***MODIFICATION REQUEST:
Sydney CityGrid Stage 1 – Belmore Park
Zone Substation -Through Site Link
Haymarket
MP 08_0075 MOD 1***

Director-General's
Environmental Assessment Report
Section 75W of the
Environmental Planning and Assessment Act 1979

December 2012

ZN 5959 BELMORE PARK ARCHITECTURAL PUBLIC DOMAIN PLAN SUBSTATION LEVEL 03 - THROUGH SITE LINK			
DRAWING No	201515	SHEET 1	AMD 01
SIZE	A0

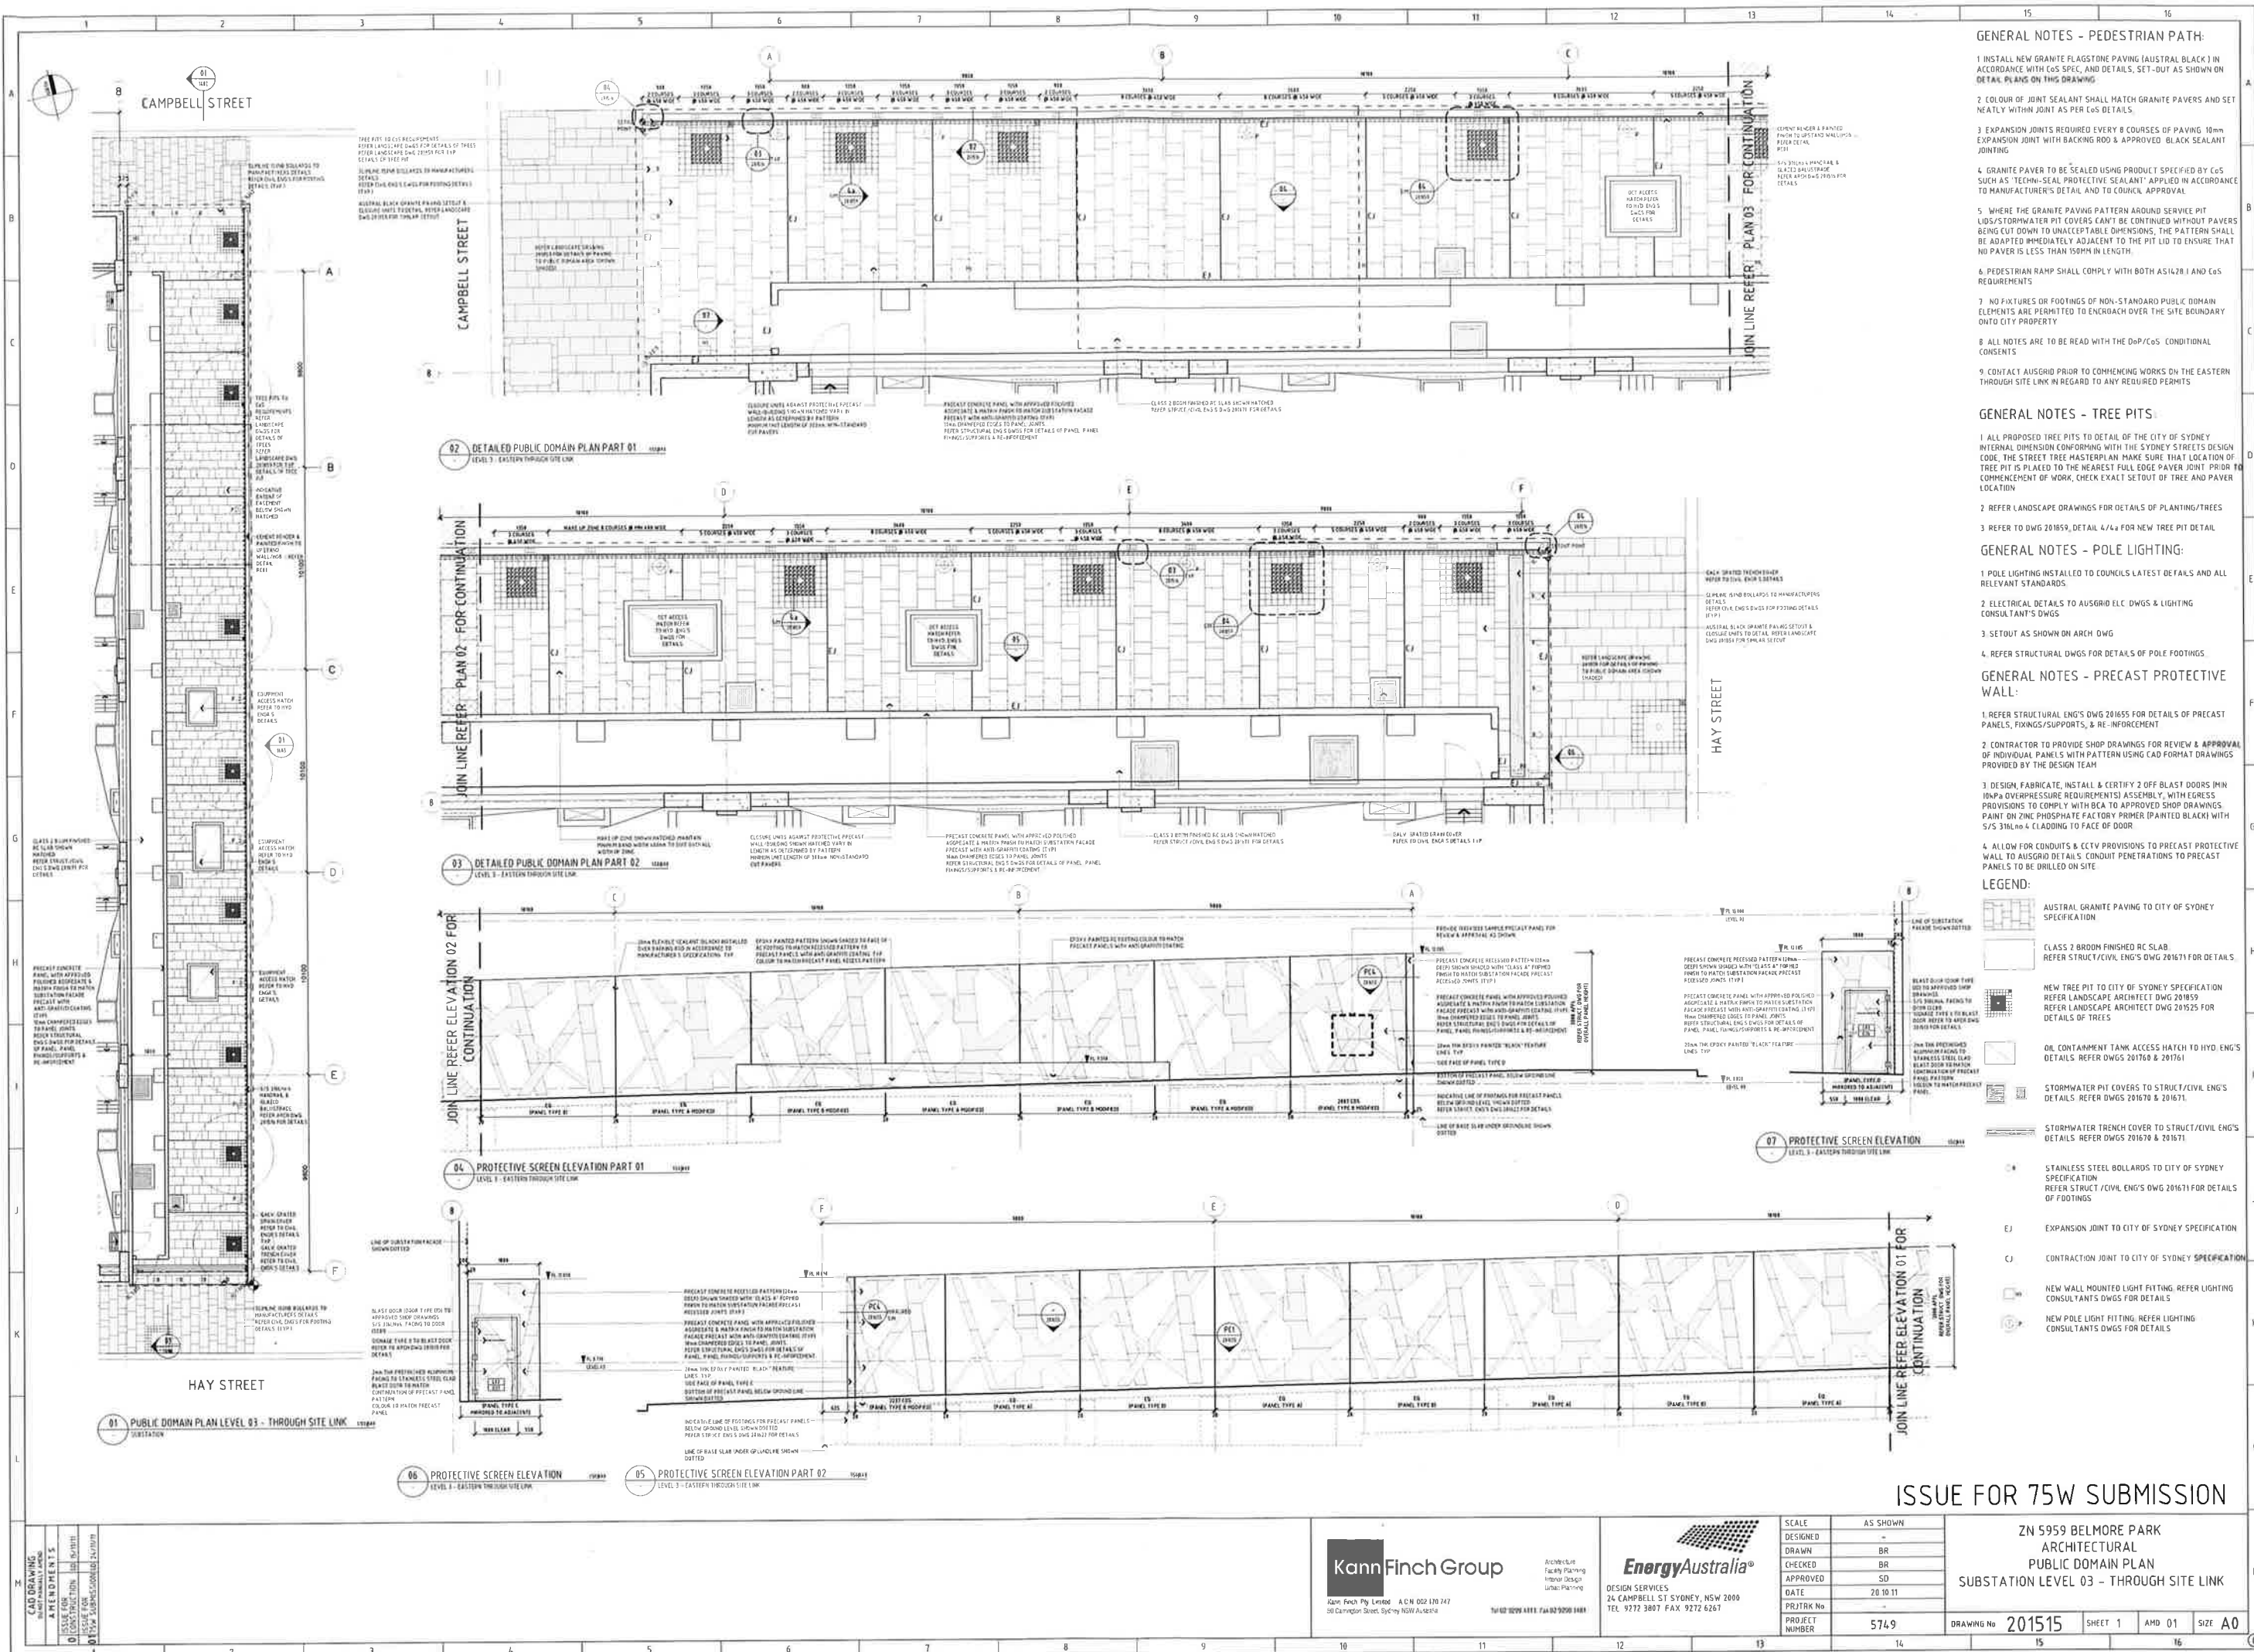
Additionally, lighting should accord with the relevant Australian Standards. The typical post top light fitting is approximately 4 metres high. It is suggested the stratum reflect this height at a minimum (6 metres would be preferred). Lower lights, as sketched are not desirable.

Materials, furniture and lighting should be consistent with Sydney Street & Sydney Lights Design Codes (granite paving) to reinforce the public route.

Tree planting to follow standards established in the Street Tree Master plan, including installation size, planting hole depth and width preparation, sub soil drainage etc. The City's Arboricultural Services team could advise and appropriate species, consistent with the master plan proposals for adjacent streets.

Finally, In lieu of a glass balustrade, it is recommended a metal palisade design be explored.

- 2.1A The Proponent shall prepare and implement a **Through-site Link Design and Safety Management Plan**, in consultation with the Council, detailing the measures to mitigate and manage security and design issues associated with the operation of the link including, but not necessarily limited to:
- a) measures to mitigate and manage security hazards (such as the closure of the link during night periods or the installation of CCTV surveillance camera(s) at strategic points within the link);
 - b) design and lighting treatments; and
 - c) landscaping treatments.

- 2.1B The Proponent shall ensure the design and landscaping treatments required under condition 2.1A of this approval include:
- a) public domain materials to express that the through-site link provides public access; and
 - b) appropriate native plantings of trees and shrubs to suit the environment of the eastern section of the site.
